KIRKLEES METROPOLITAN COUNCIL INVESTMENT & REGENERATION SERVICE

DELEGATED DECISION TO DETERMINE PLANNING APPLICATIONS

Reference No:	2026/62/90043/W
Site Address:	The Cherries, 8, Rossefield Avenue, Birkby, Huddersfield, HD2 2BR
Description:	Erection of two storey side and single storey rear extensions
Recommending Officer:	Elenya Jackson

Drawing
Proposed Level 1

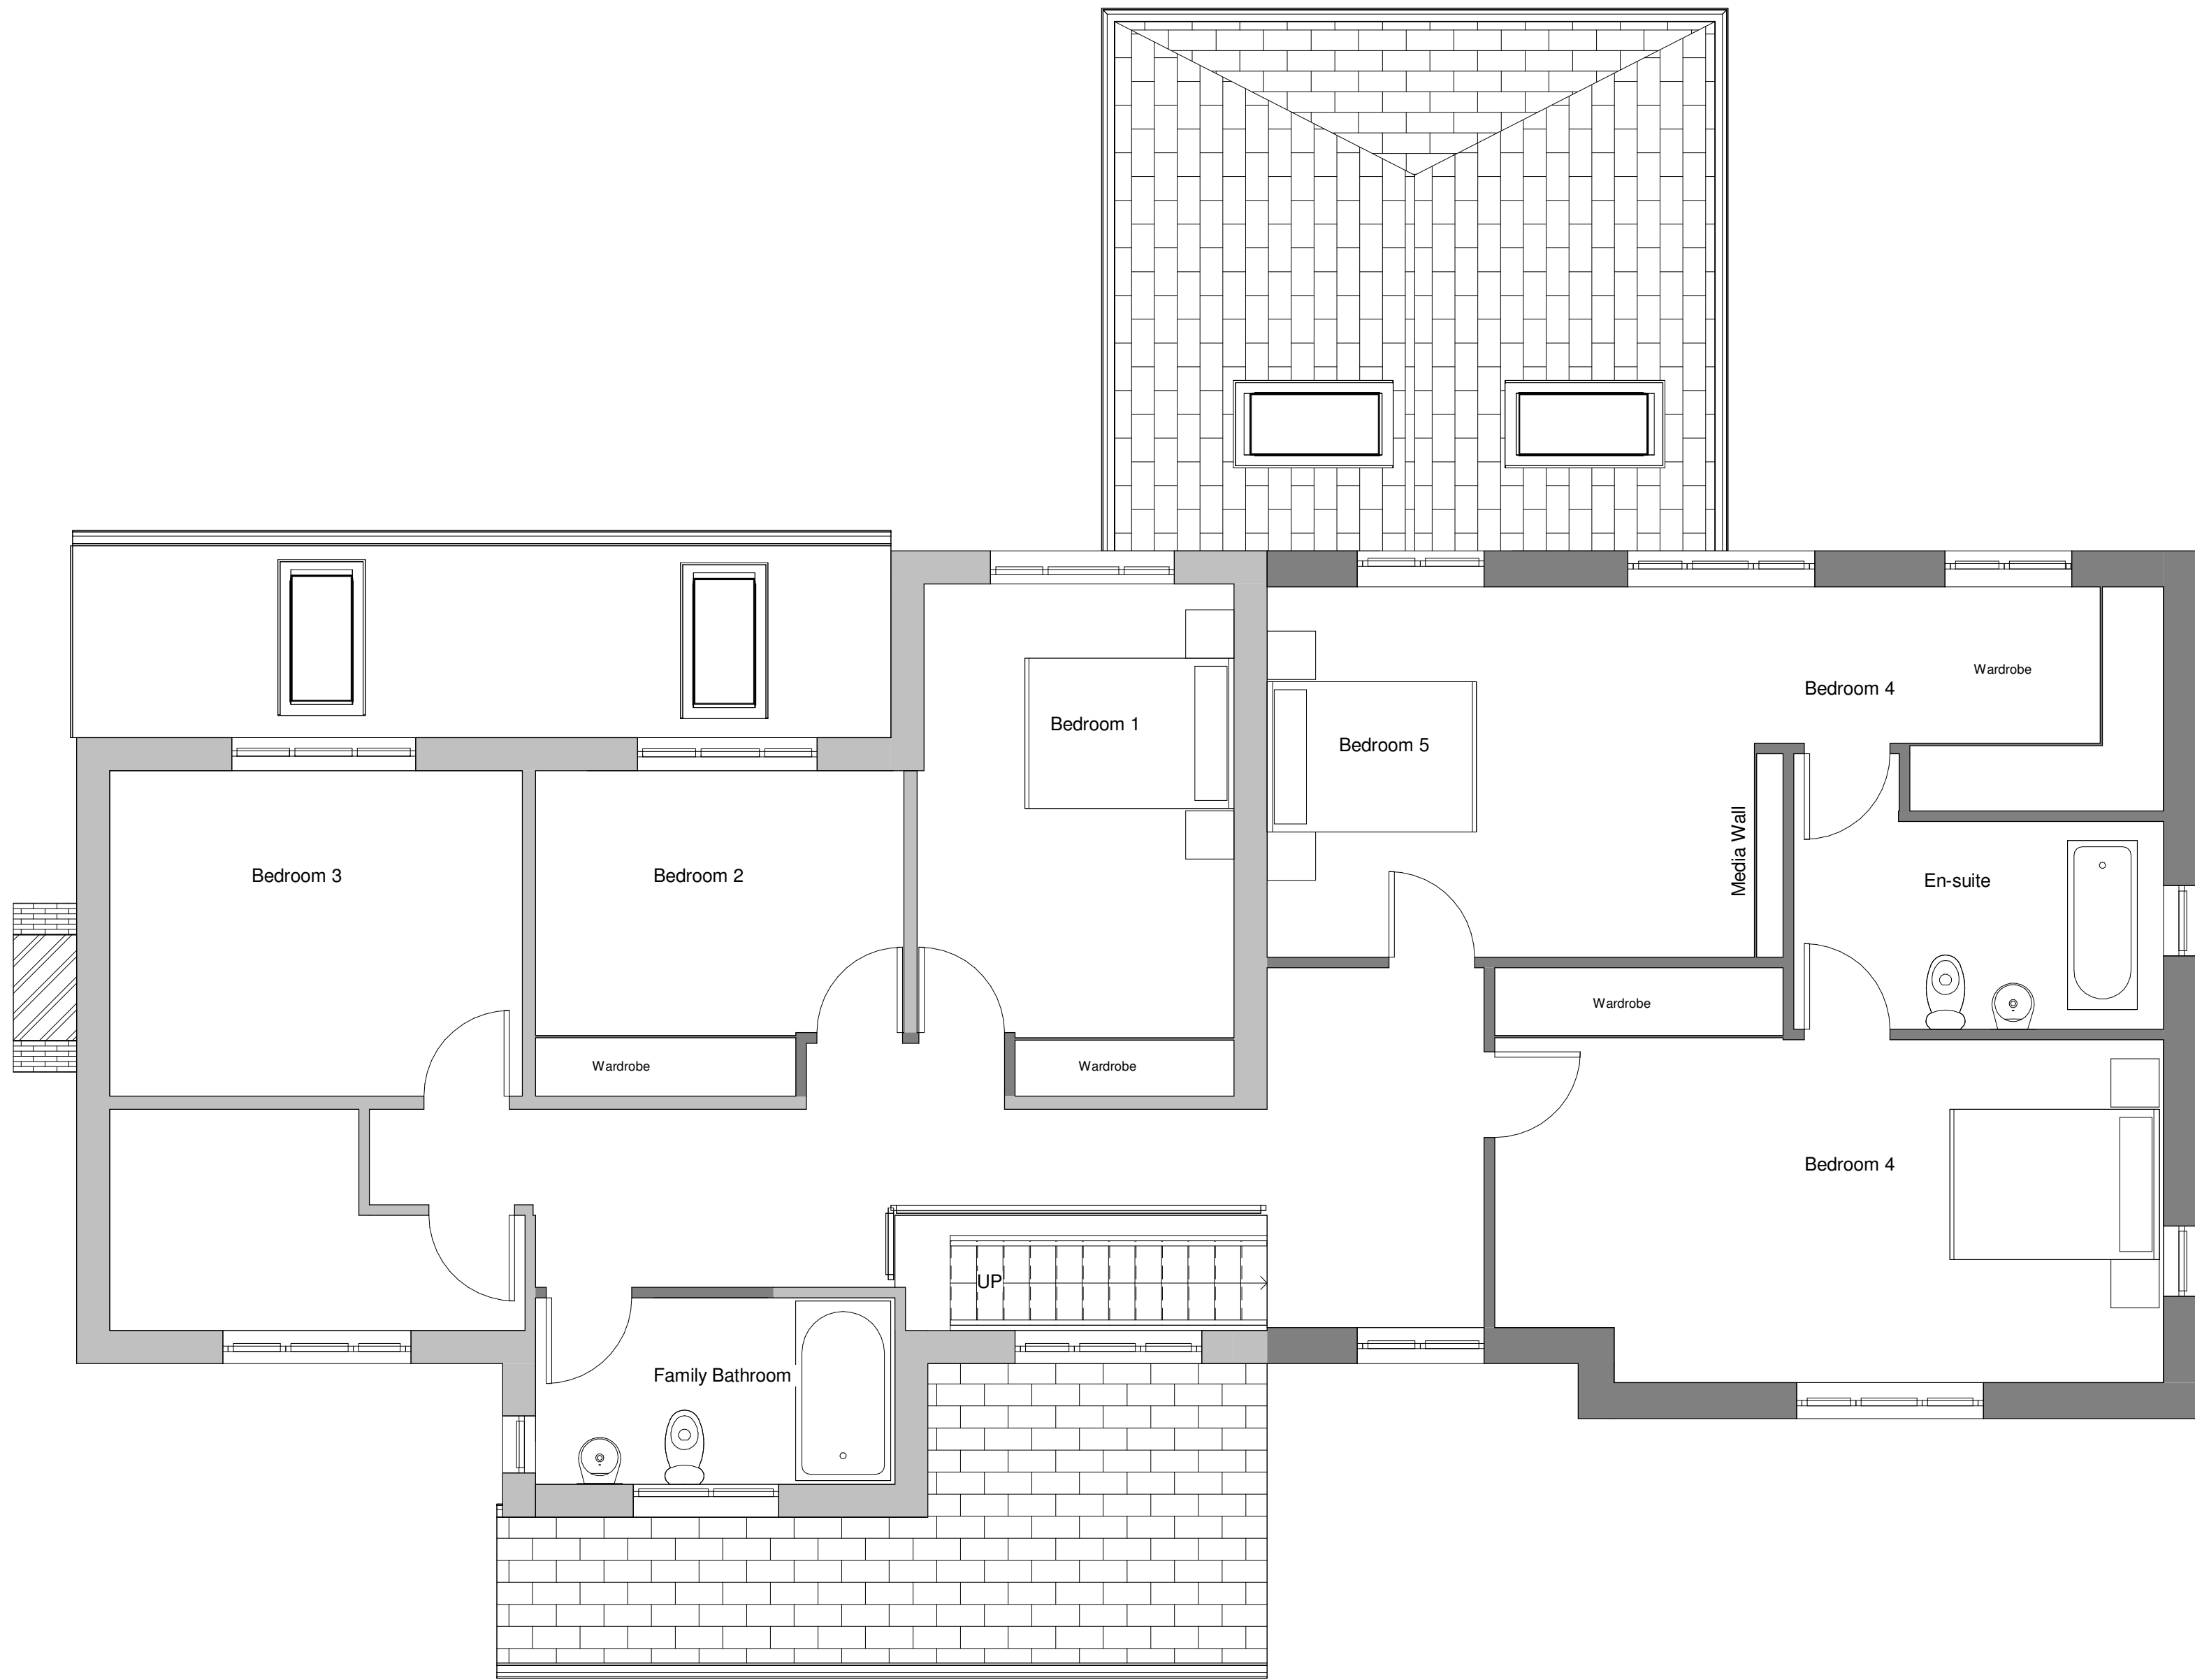
The existing dwelling has a single storey projection on its southern elevation. The two storey side extension would project 8.8m beyond the existing two storey element of the dwelling to the south. This would feature a gable end with a maximum height of 7m and an eaves height matching the existing dwelling.

It is considered by officers that the width of the first floor side extension is somewhat pre-determined by the width of the existing ground floor extensions. Which, although large in scale, would be in-keeping with the host dwelling. The proposed extension would be constructed out of materials matching the host dwelling which would aid integration with the host property and balance existing projections on site. As previously indicated, the dwelling is a stand alone property and its vernacular is not uniform with other properties in the vicinity; therefore, some variance in its design would not be out of keeping in the context of the area. Furthermore, due to the spacious plot and its separation from the public realm, an extension of a larger scale can be accommodated without impacting on visual amenity.

Overlooking: The proposal would introduce rear facing windows at first floor level on the southern elevation of the site. It is considered that the windows would have an offset relationship with the rear of these properties and would retain the existing separation distance. Therefore, no significant issues would be raised regarding overlooking.

Drawing
Proposed Level 0

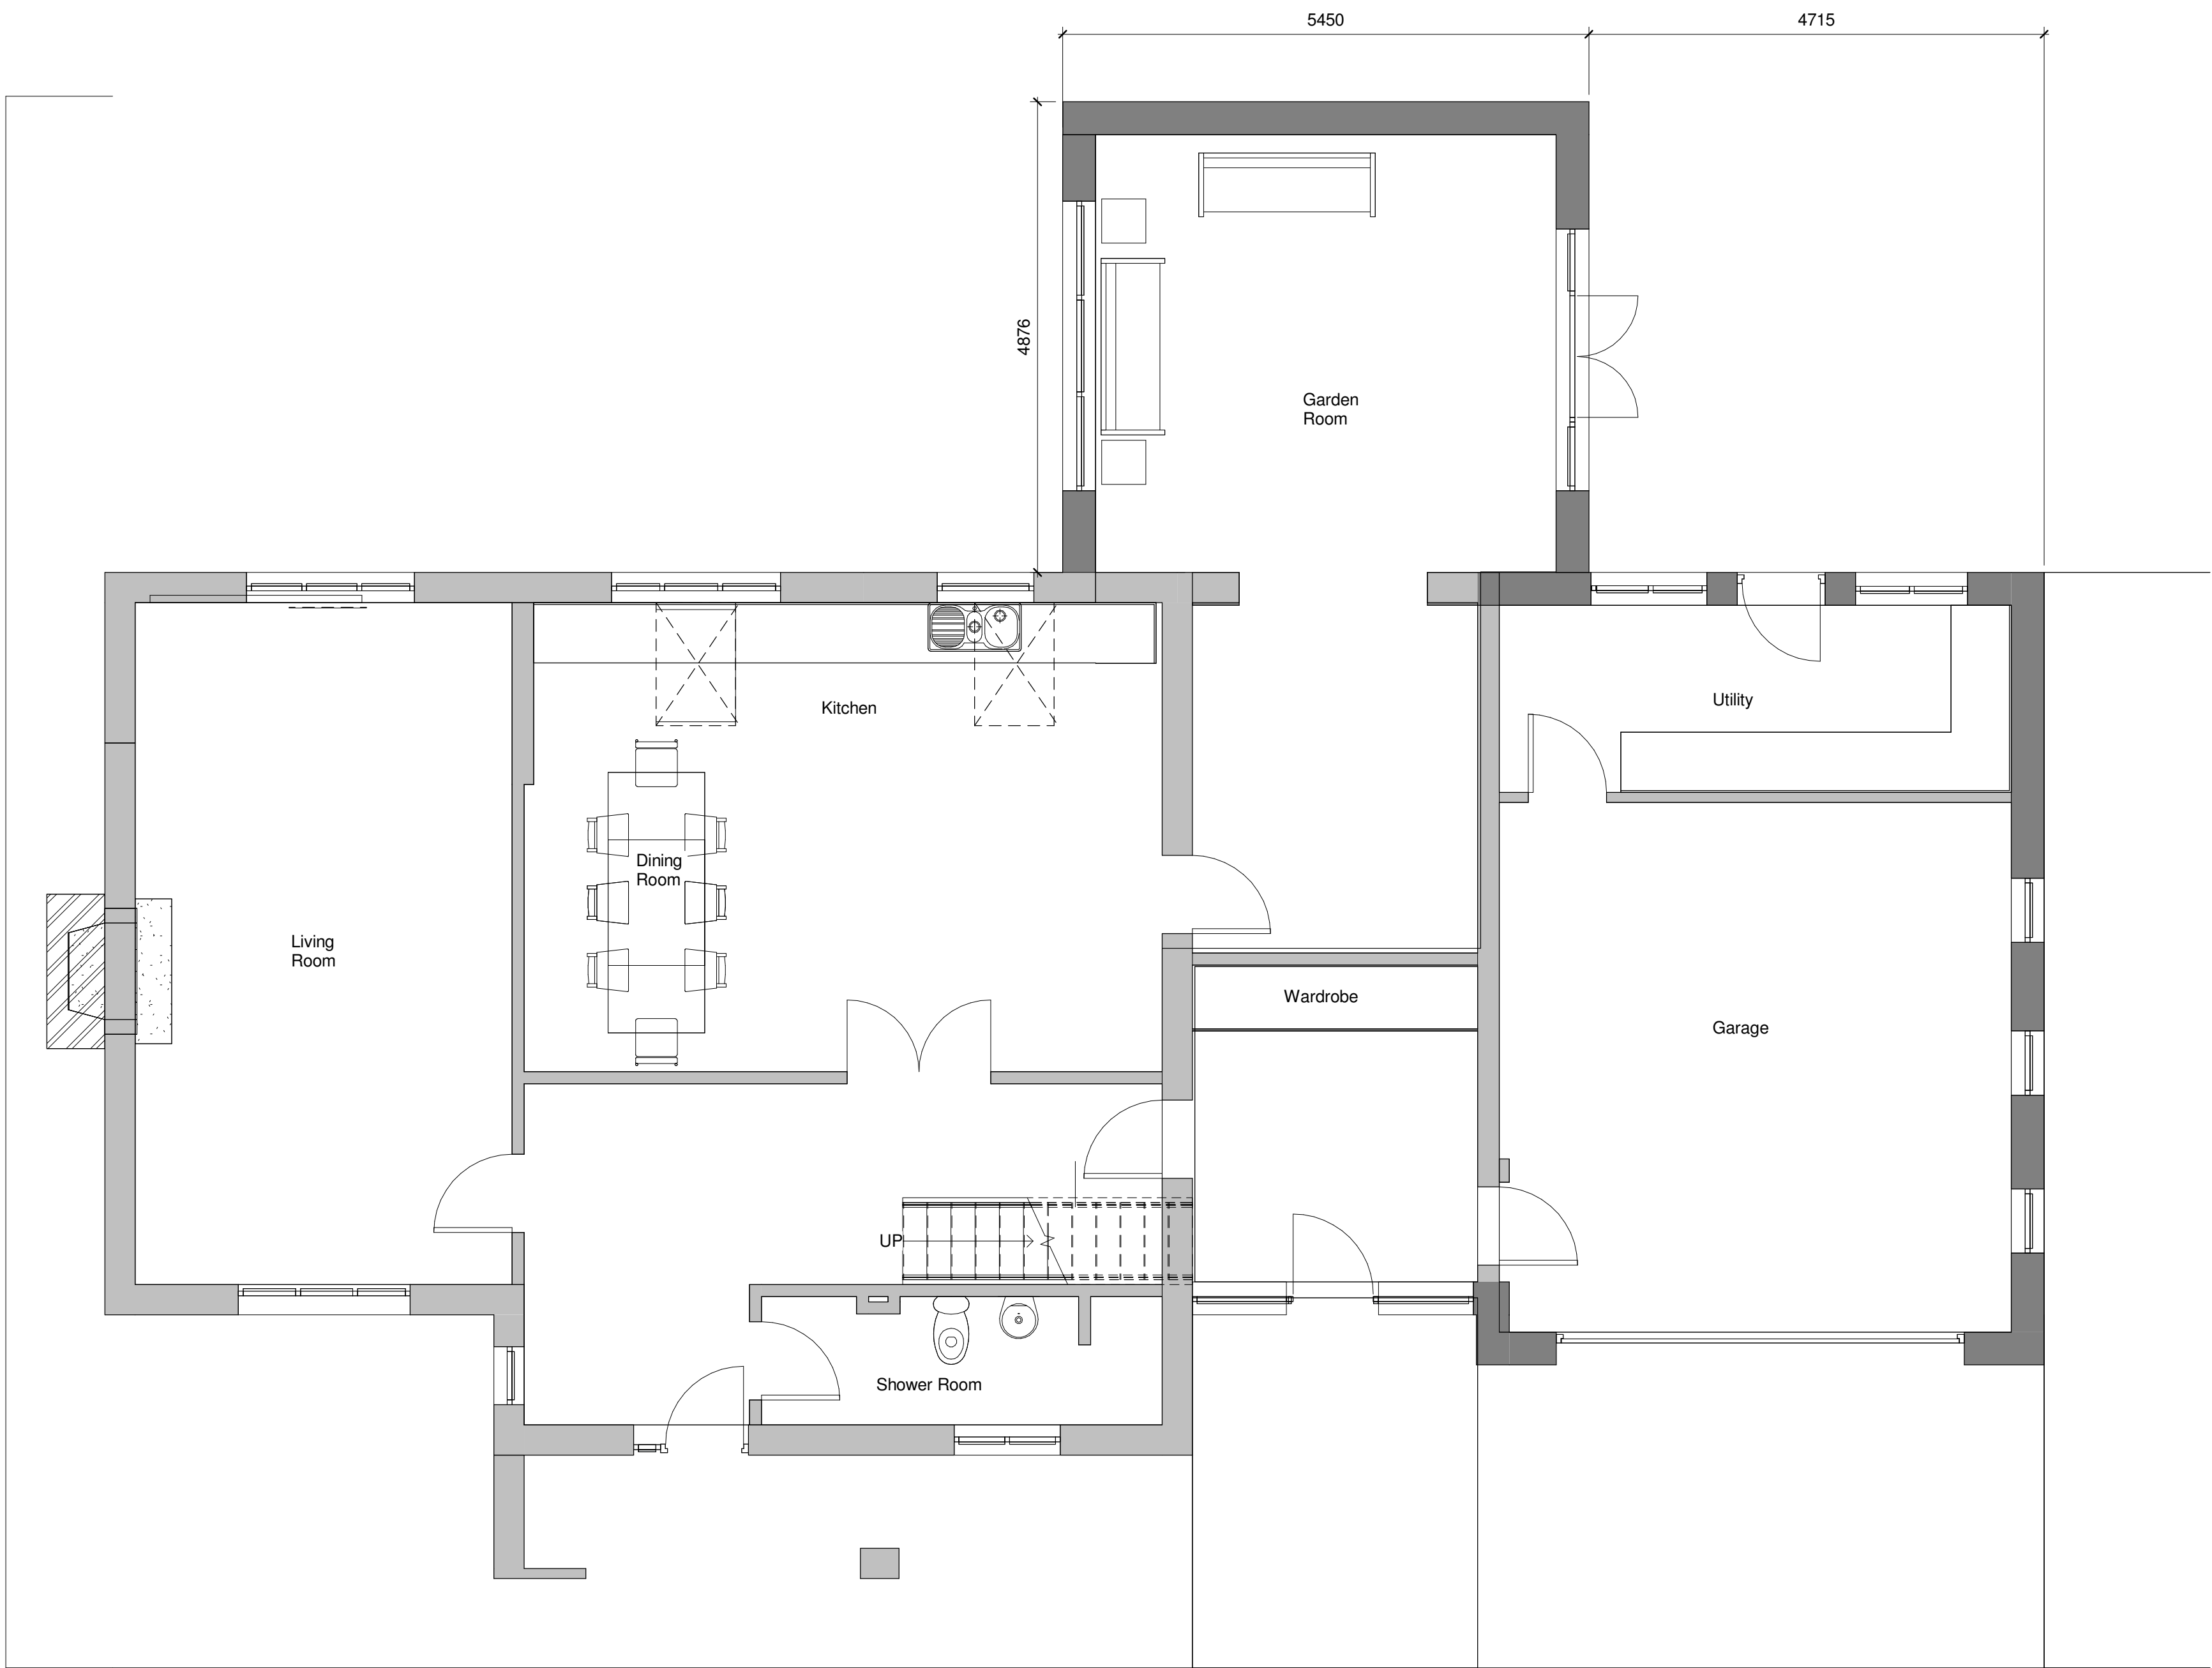
The single storey rear alterations would include the addition of a lean-to roof over the existing rear elevation of the property and the replacement of an existing orangery with a single storey hipped roof extension. This would extend 4.8m beyond the rear elevation of the host property and have a width of 5.5m and a maximum height of 3.6m.

The rear extension would project 90cm further than the dimensions stipulated within the SPD; however, officers consider that the property benefits from ample amenity space and in the context of the site, the additional depth would be marginal in this instance.
